**Crown Lands Division  
Far North Coast**

Our reference: **09/08674**  
Your reference: **05\_0129**

01 October 2009

**Re: 'Lakes Estate' 198 Lot Residential Subdivision at Lakes Drive and North Boambee Road, North Boambee Valley, Coffs Harbour LGA (05 0129)**

Figure 37 - Areas of vegetation removal (Source: CPG Australia 2009)

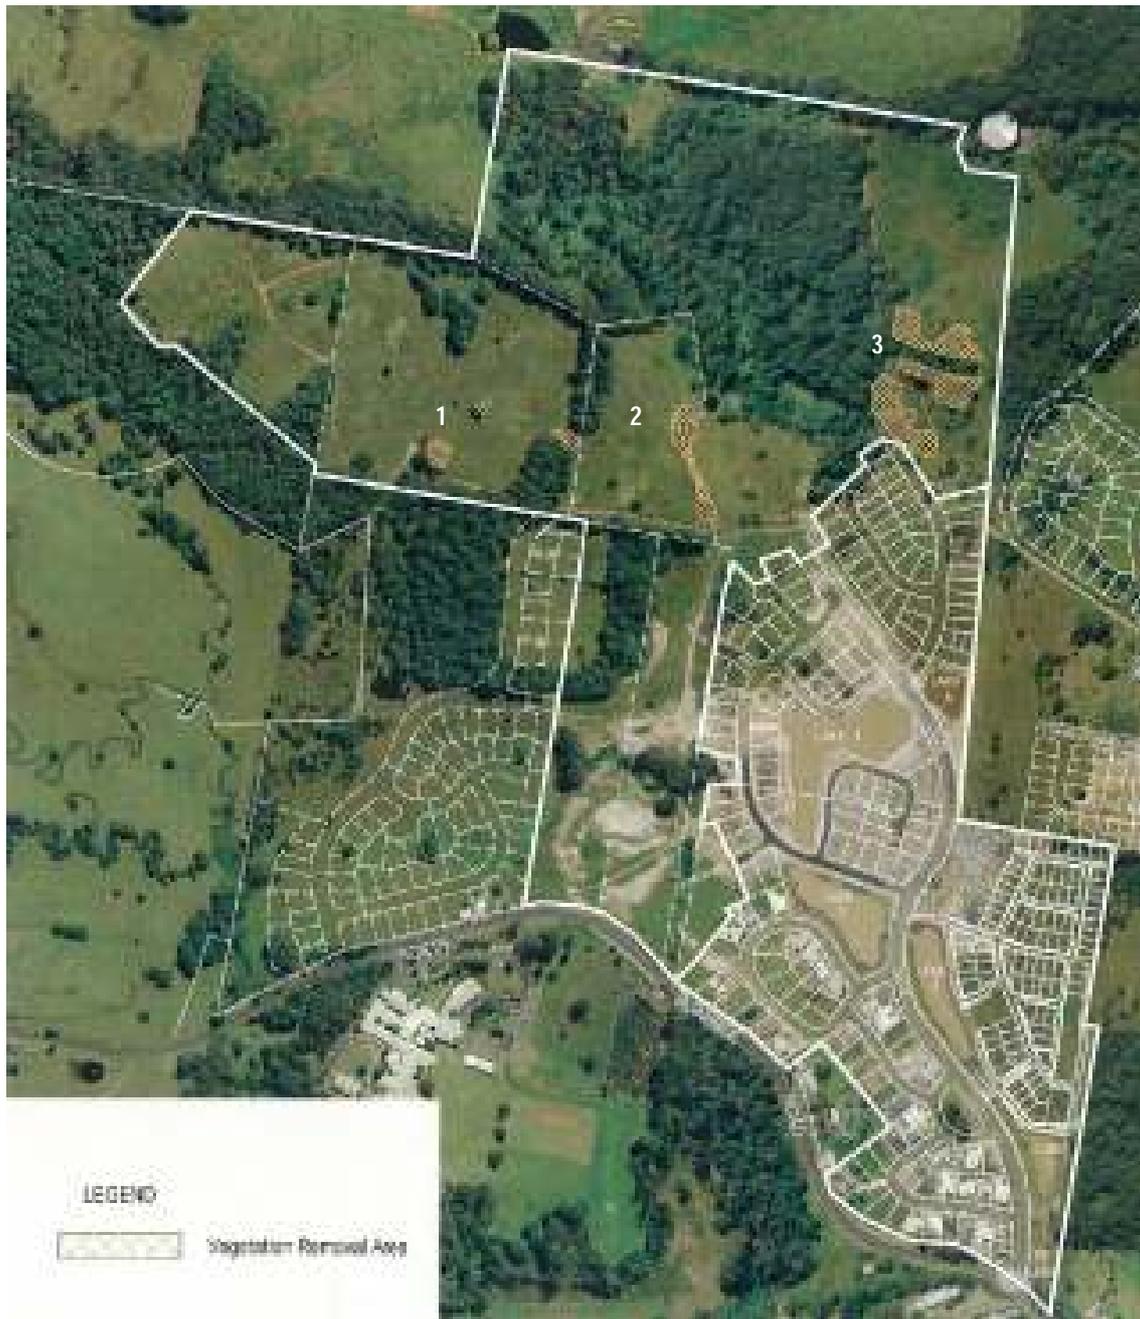
- of EEC (including for noise attenuation along the proposed Pacific Highway Bypass route).
- Figure 43 suggests some of the vegetation to be removed in the North-eastern Precinct (Location 3 in Figure 37) constitutes the easternmost extent of the EEC, which is also identified as primary koala habitat, threatened frog habitat, and very high conservation value vegetation. The LPMA does not support the removal or modification of the EEC in this location.

- It is noted the extent of primary and secondary koala habitat indicated on Figure 38 differs from that shown on Figure 41 (Figure 41 being based upon assessments undertaken by EcoLogical Australia Pty Ltd in Appendix BB). As the estimated area of koala habitat expected to be removed is based upon Figure 38, the area of koala habitat actually removed may differ from that estimated.

- It is difficult to reconcile the third draft commitment under 'Flora and Fauna' ("*All vegetation which is identified as Primary or Secondary koala habitat, remnant vegetation or within identified corridors and occurs within created allotments will not be removed for future residential development*") with what is presented in Figure 38 and the fact that future lots 33 – 35 are almost completely covered in remnant vegetation.

Figure 40 - Vegetation communities identified within the subject site (Source: Eco-Logical Australia 2007)

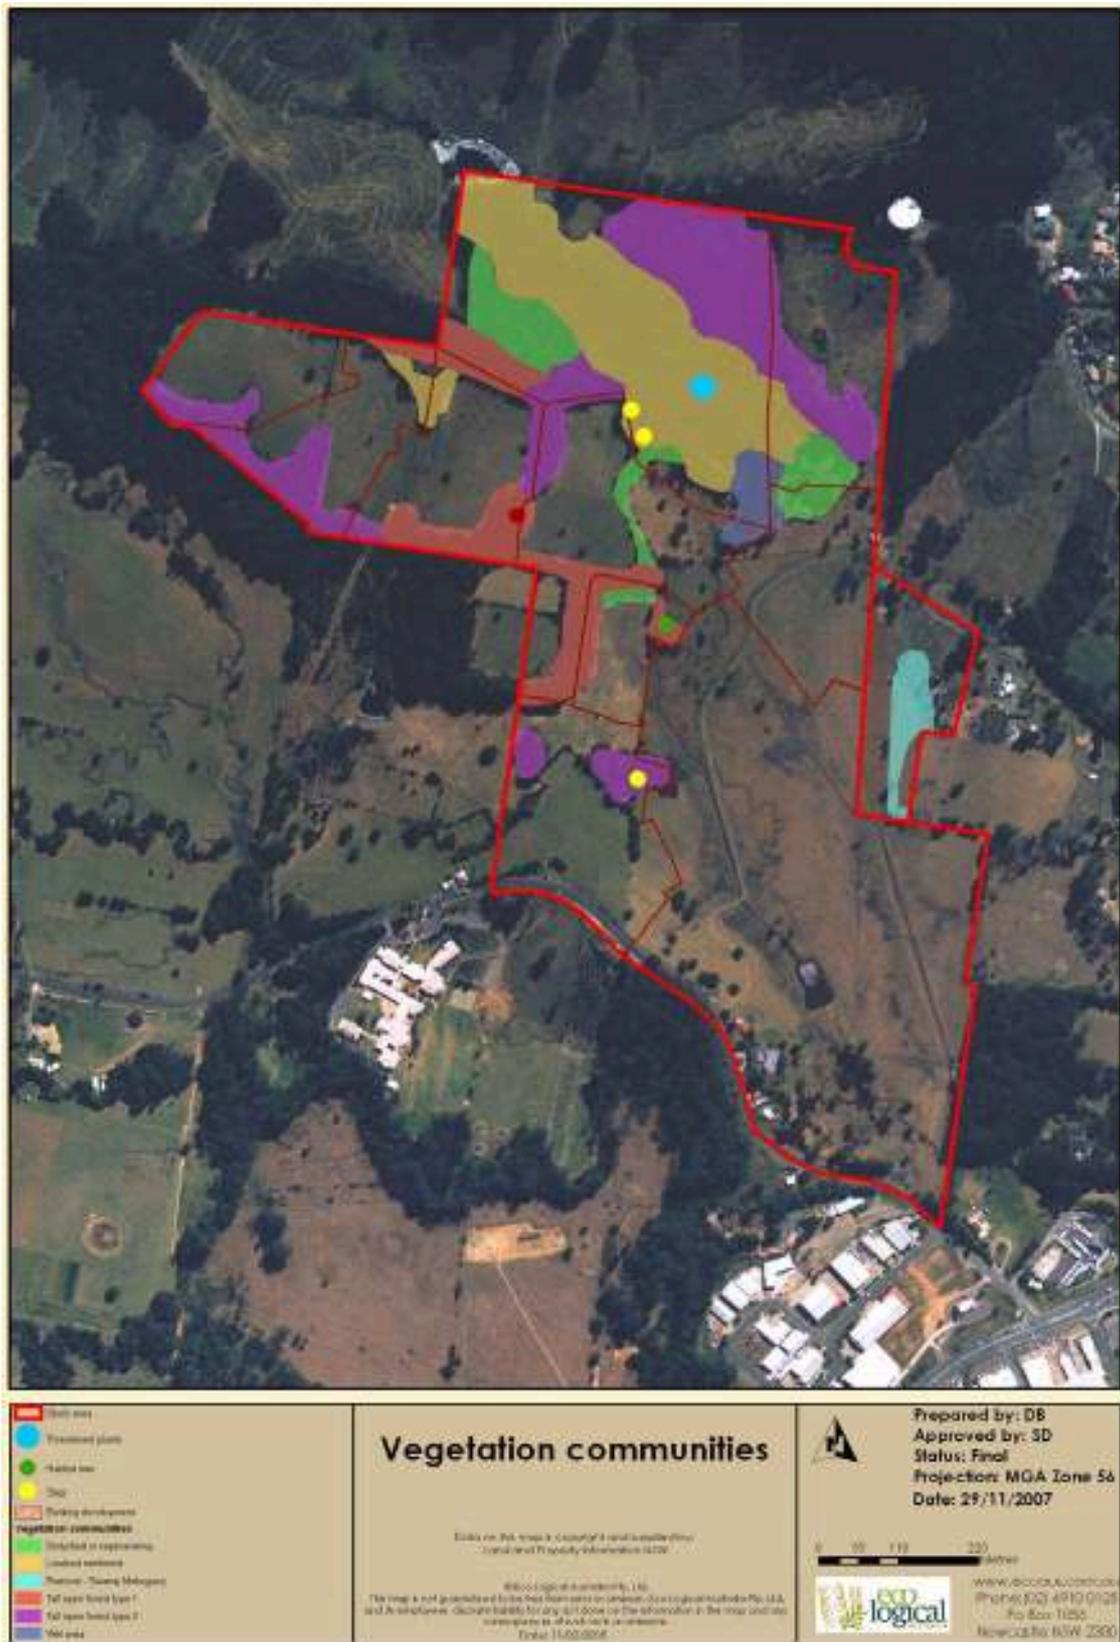
- It is noted an area of high conservation value vegetation (identified as Tall Open Forest Type 2 – Blackbutt – Tallowwood – Broad-leaved White Mahogany in Figure 40) currently exists in the southern portion of Lot 10 DP1071628. Subdivision plans for Stage 1 suggest this vegetation will be removed to accommodate future lots 32 - 35. However, the vegetation isn't identified as being slated for removal in Figure 38. It is also noted the vegetation provides a partial corridor between the primary and secondary koala habitat in the centre of Lot 2 DP607602 and the primary koala habitat in the centre of Lot 10 DP1071628. It is recommended, therefore, the vegetation be retained and its ecological function enhanced through incorporation into a dedicated corridor between the koala habitat in Lot 2 and that in Lot 10. This will entail removing from the subdivision plan a number of the proposed allotments between the vegetation and the koala habitat. It is noted in Appendix DD street tree plantings and turf along part of Road No. 5 are expected to perform the function of a corridor between the koala habitat in Lot 2 and that in Lot 10. It is argued narrow street-tree plantings and turf do not provide as effective a wildlife corridor/ habitat linkage as retained native vegetation.
